Awel y Môr Offshore Wind Farm Limited

**Date: 18/10/2022**  
**Our Ref: PLA0068057**  
**Your Ref: EN010112**

**Site: Awel y Môr Offshore Wind Farm project, Denbighshire**

**Development: Order Granting Development Consent for the Awel y Môr Offshore Wind Farm project**

Map Ref: 303548,382436
Map scale: 1:1250
Printed by: Lester Barrow
Printed on: 18 Oct 2022

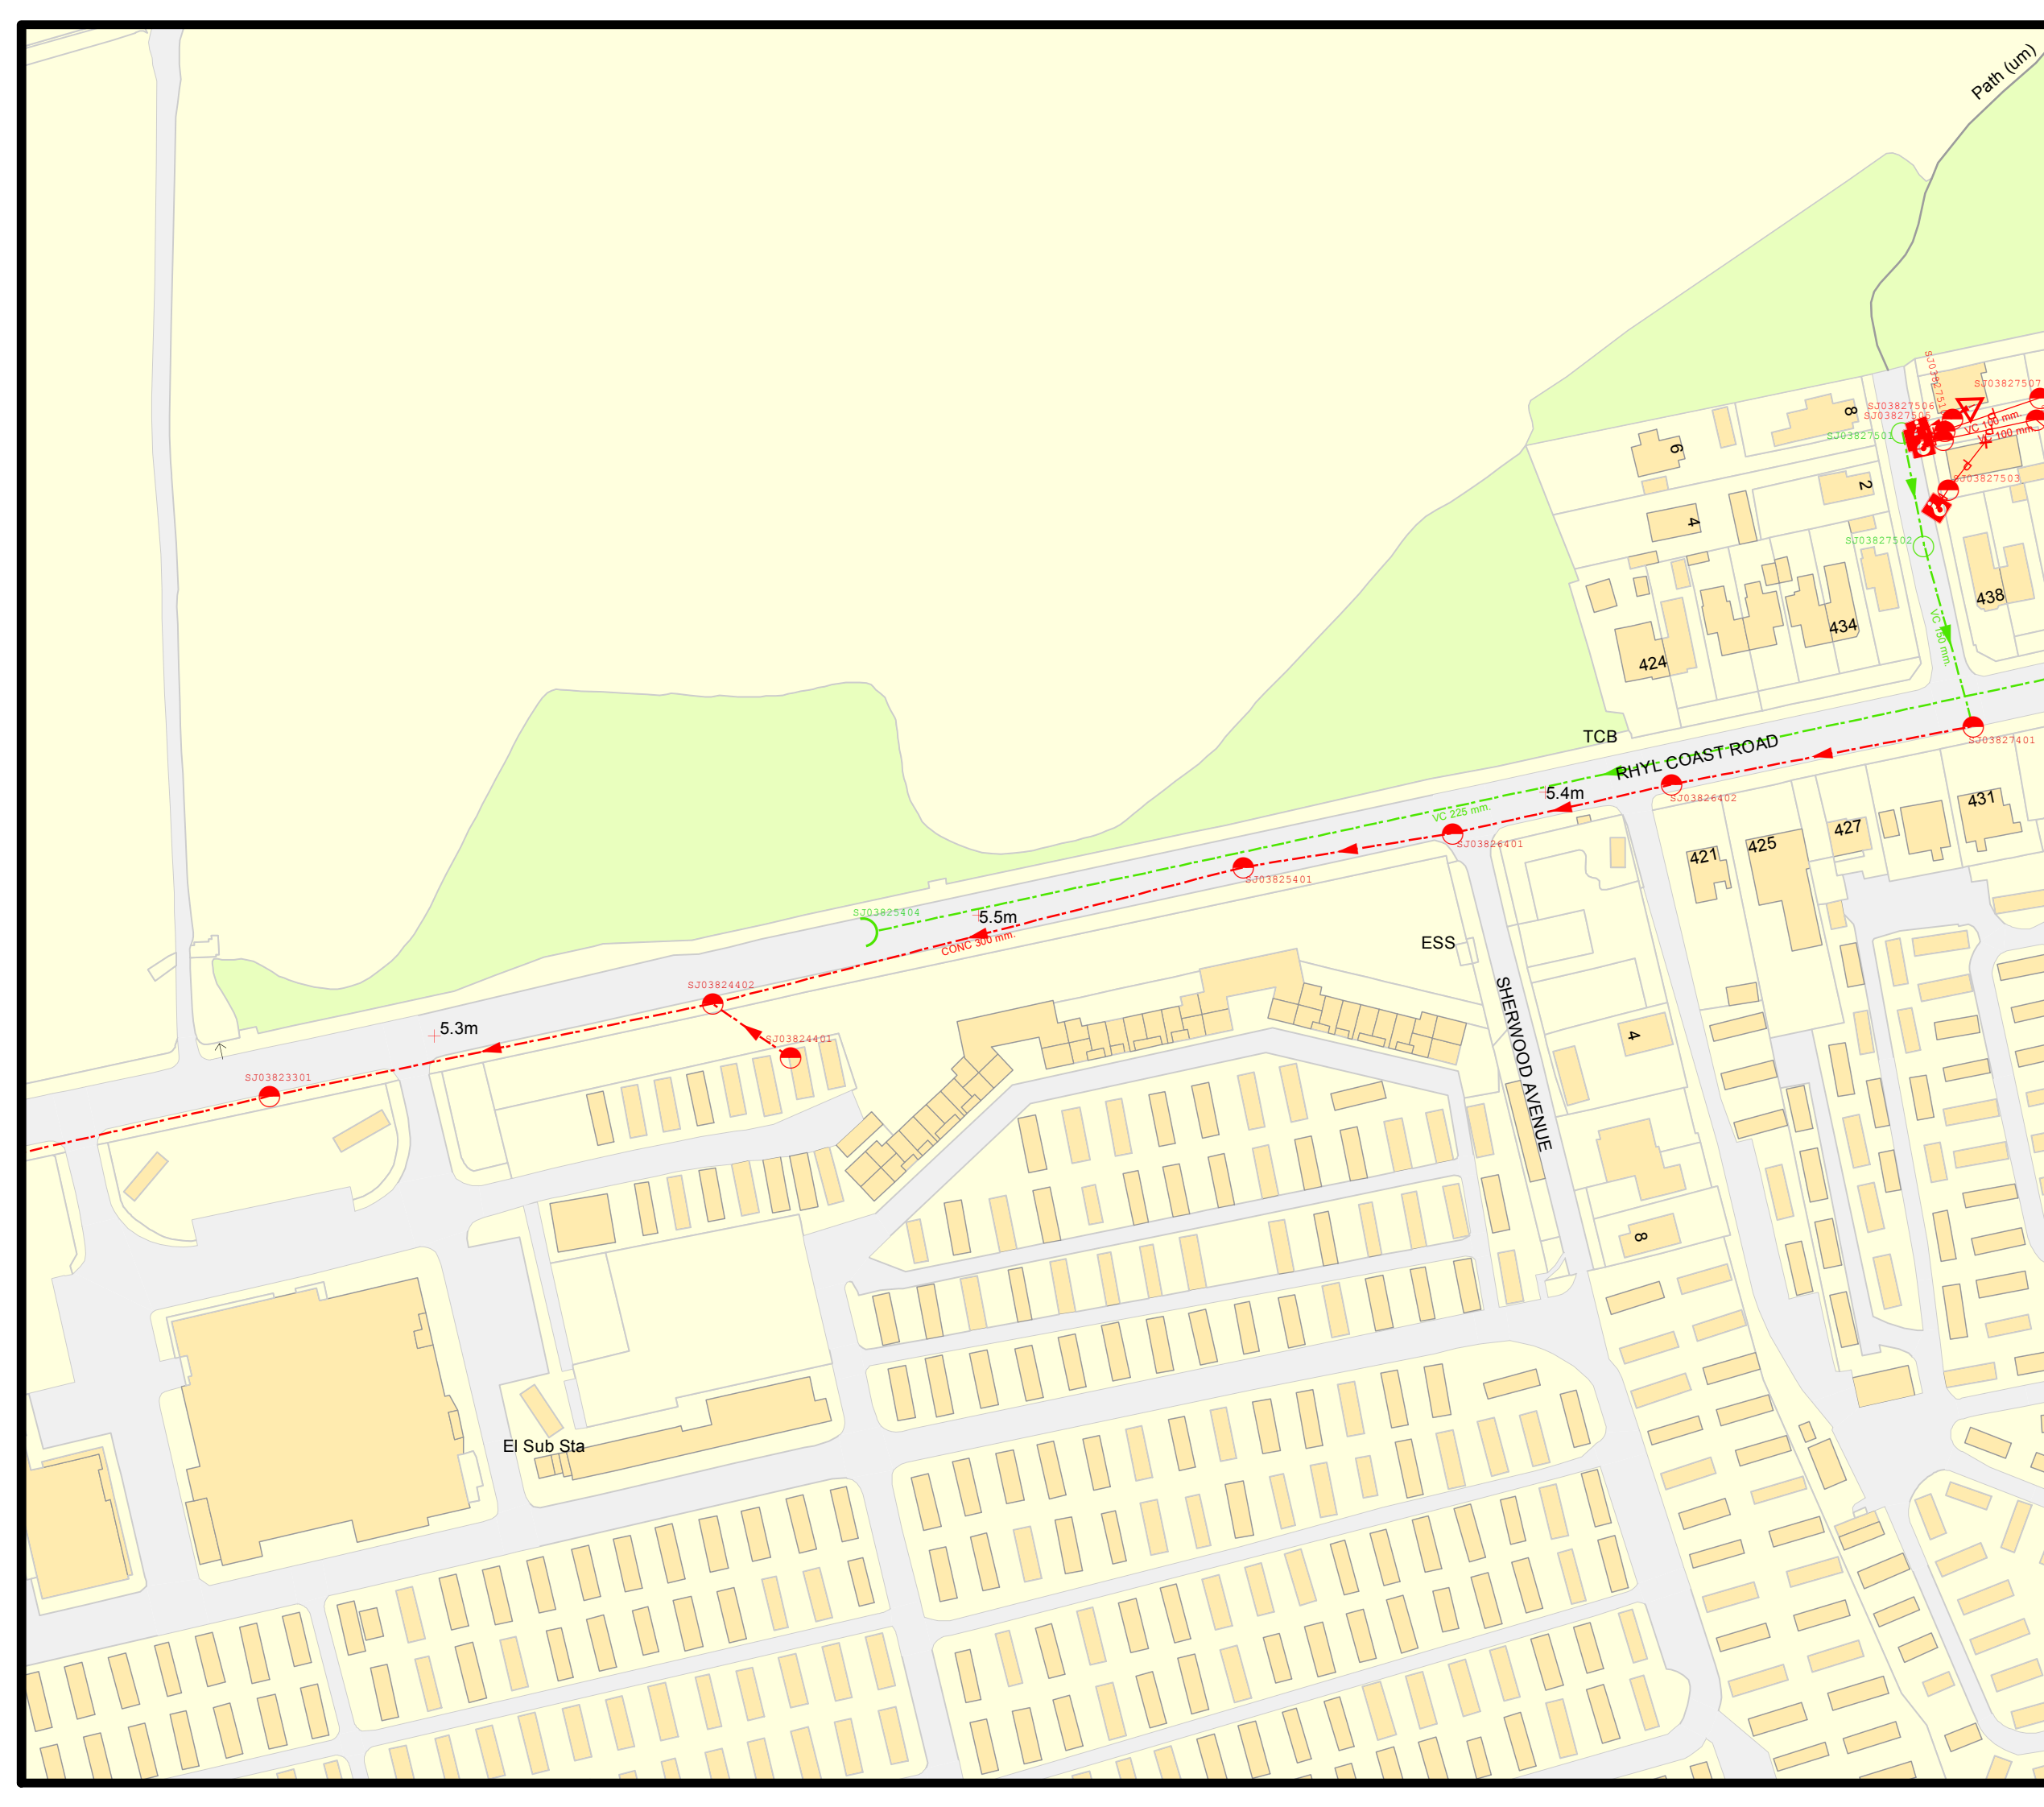
No part of any building will be permitted within 3 metres either side of the centreline of the 225mm public surface water sewer (grid reference: 303547.61, 382435.29) - sewer plan 2

No part of any building will be permitted within 3 metres either side of the centreline of the 300mm public combined sewer (grid reference: 303547.61, 382435.29) - sewer plan 2

Map Ref: 301322,378122
Map scale: 1:1250
Printed by: Lester Barrow
Printed on: 18 Oct 2022

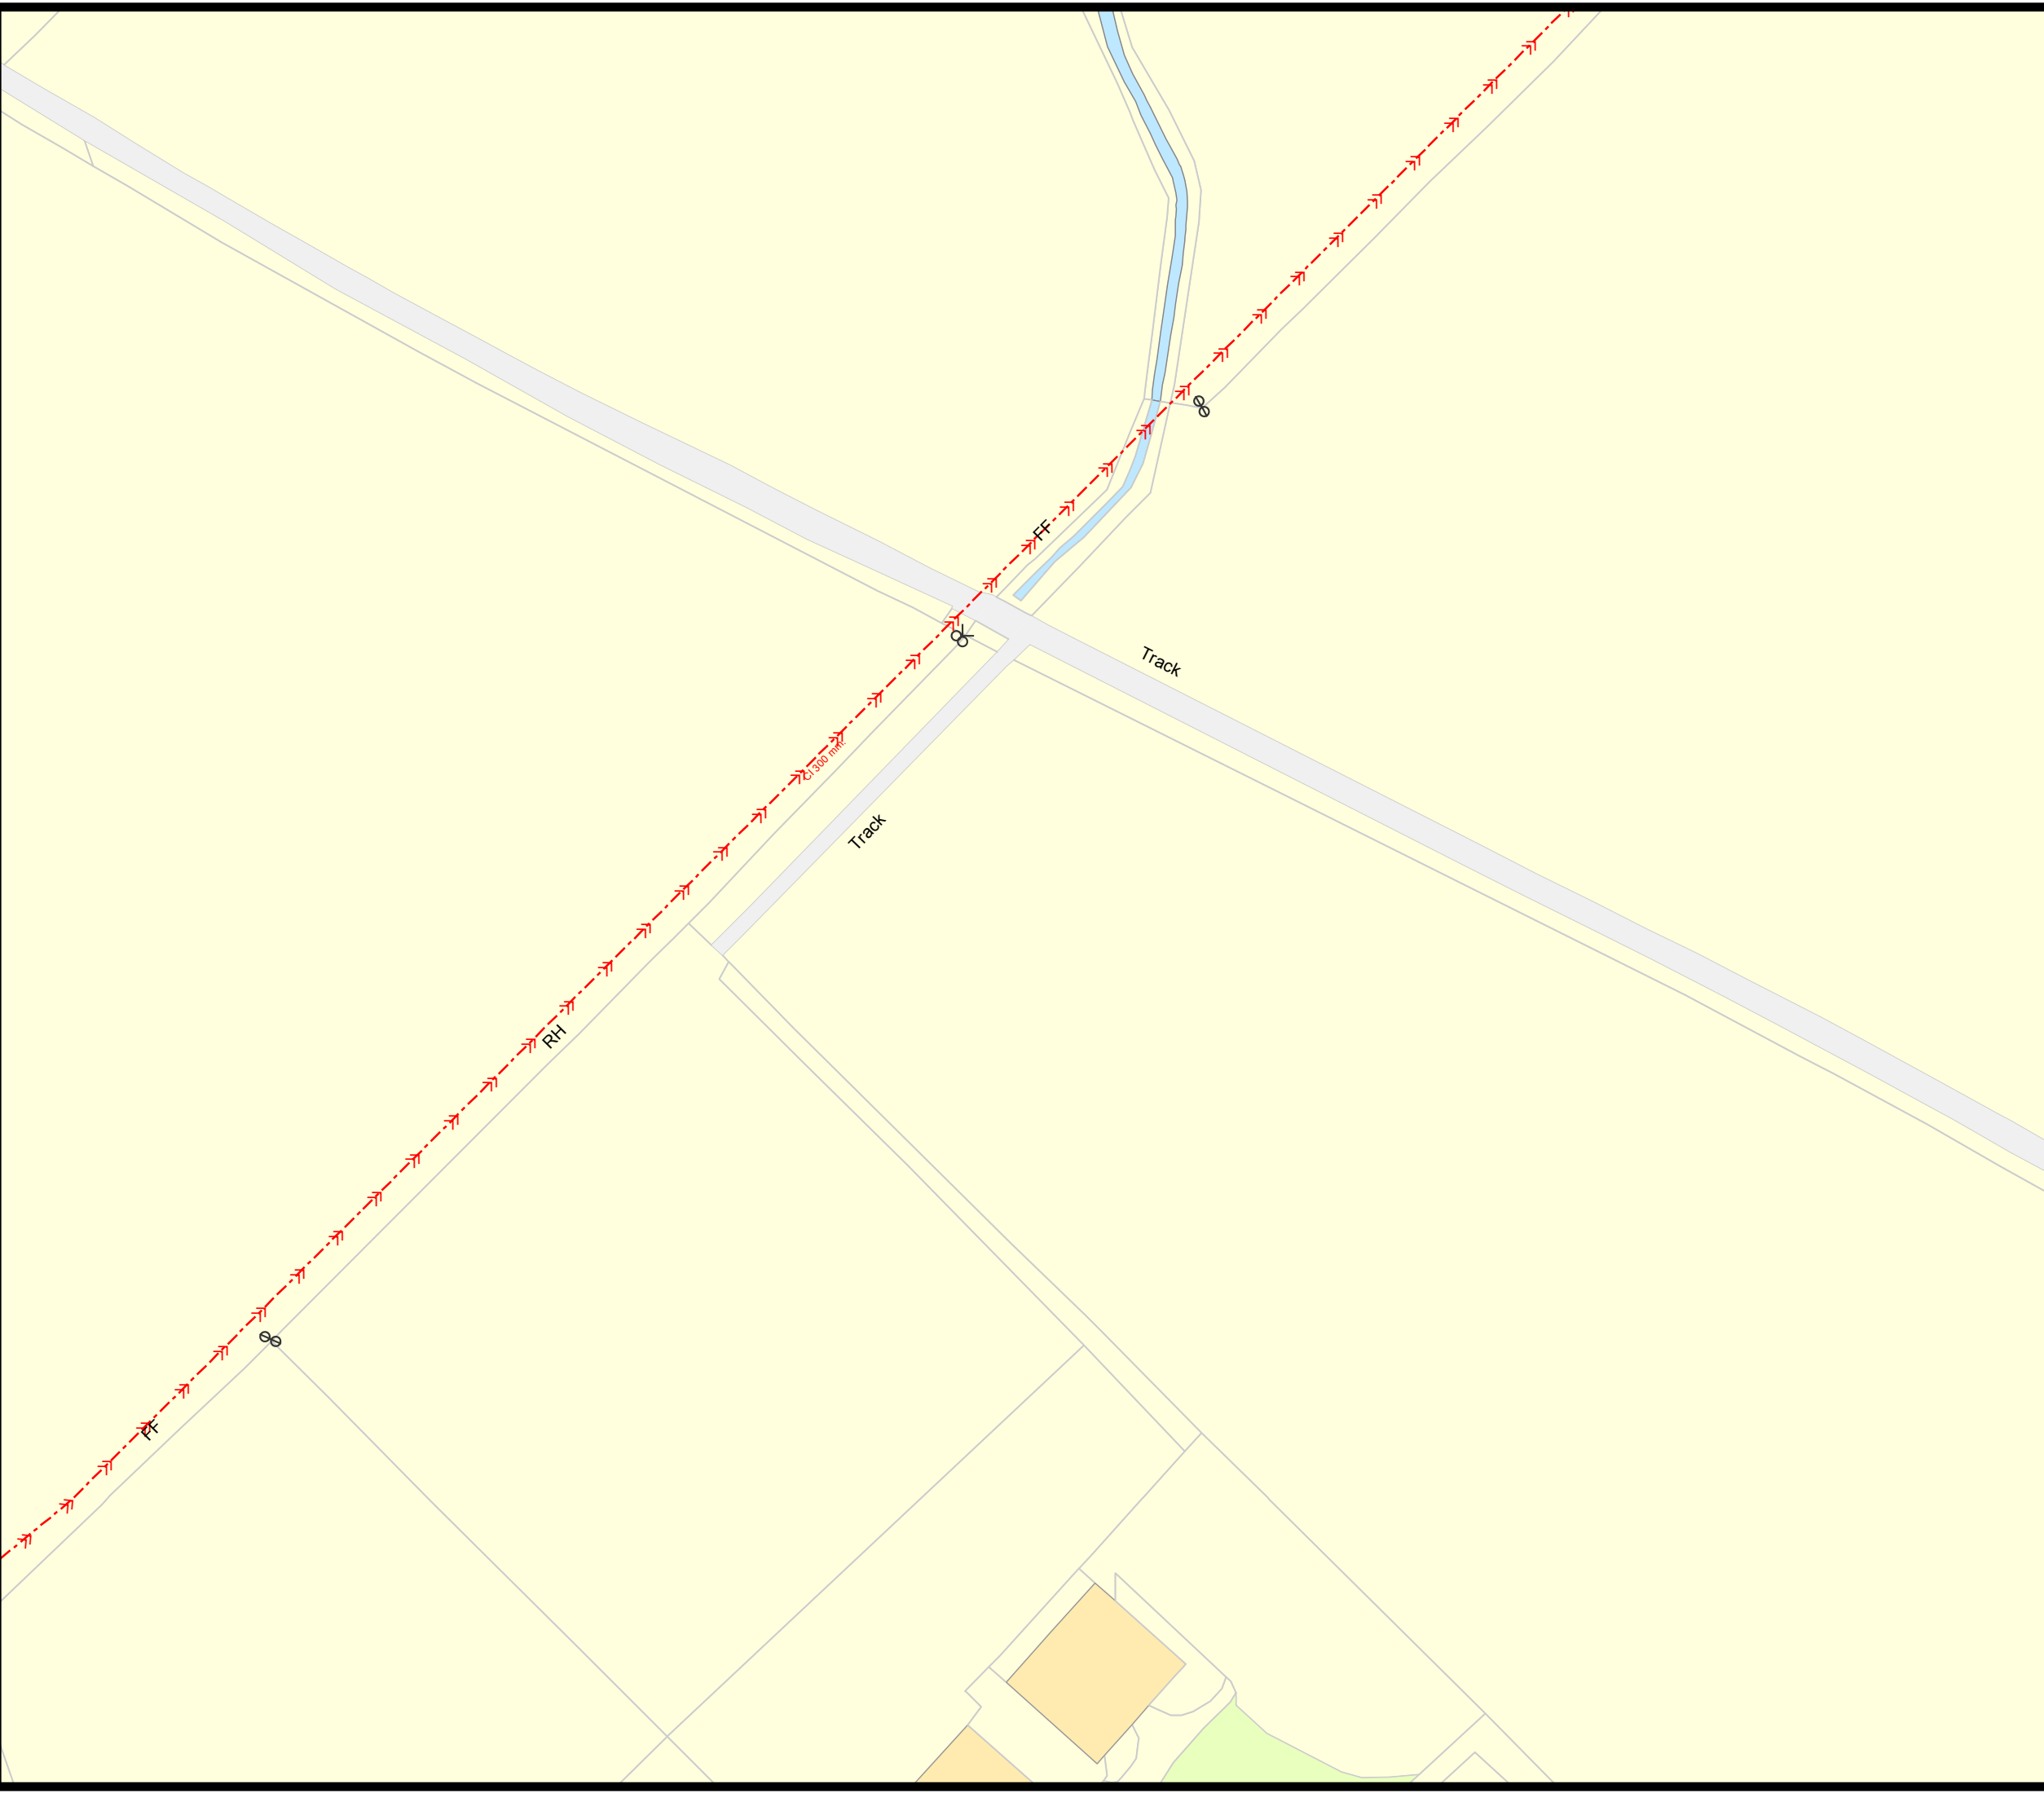
No part of any building will be permitted within 3.5 metres either side of the centreline of the 300mm public combined rising main (grid reference: 301309.85, 378183.15) - sewer plan 5

Map Ref: 301737,378613
 Map scale: 1:1250
 Printed by: Lester Barrow
 Printed on: 18 Oct 2022

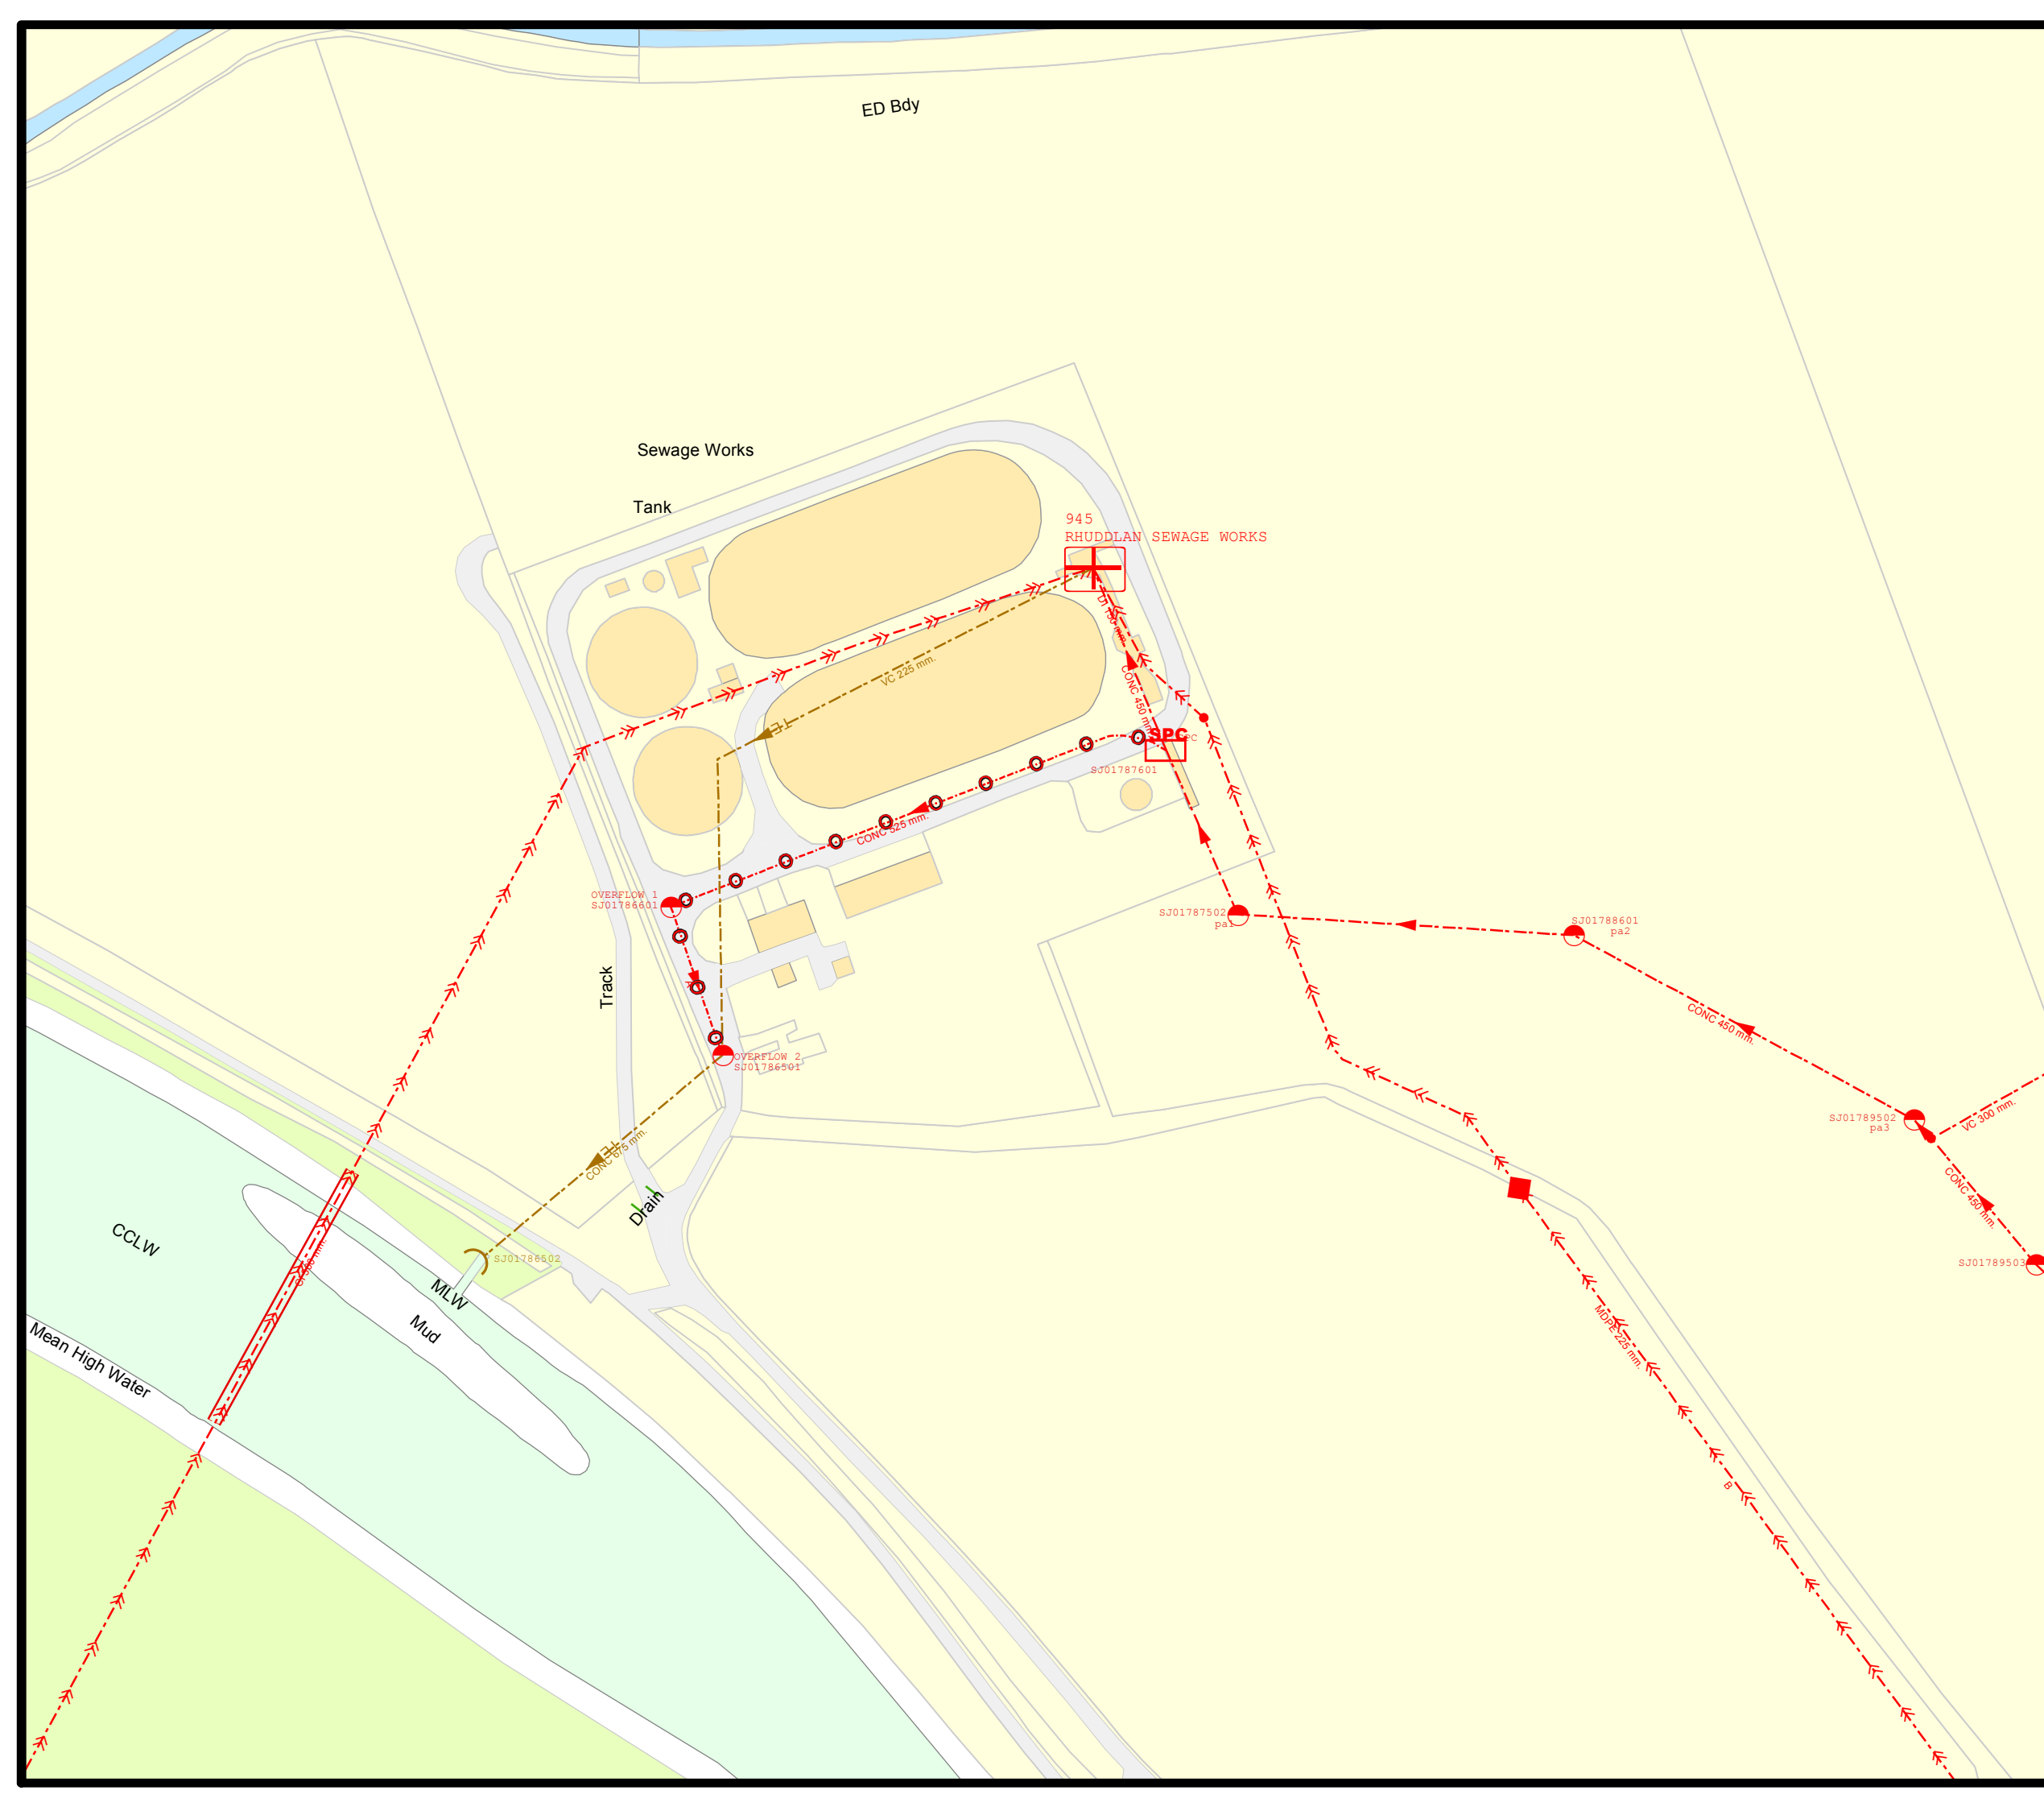
No part of any building will be permitted within 3.5 metres either side of the centreline of the 300mm public combined rising main (grid reference: 301617.12, 378599.87) - sewer plan 4

No part of any building will be permitted within 7 metres either side of the centreline of the 675mm public combined sewer (grid reference: 301650.10, 378561.40) - sewer plan 4
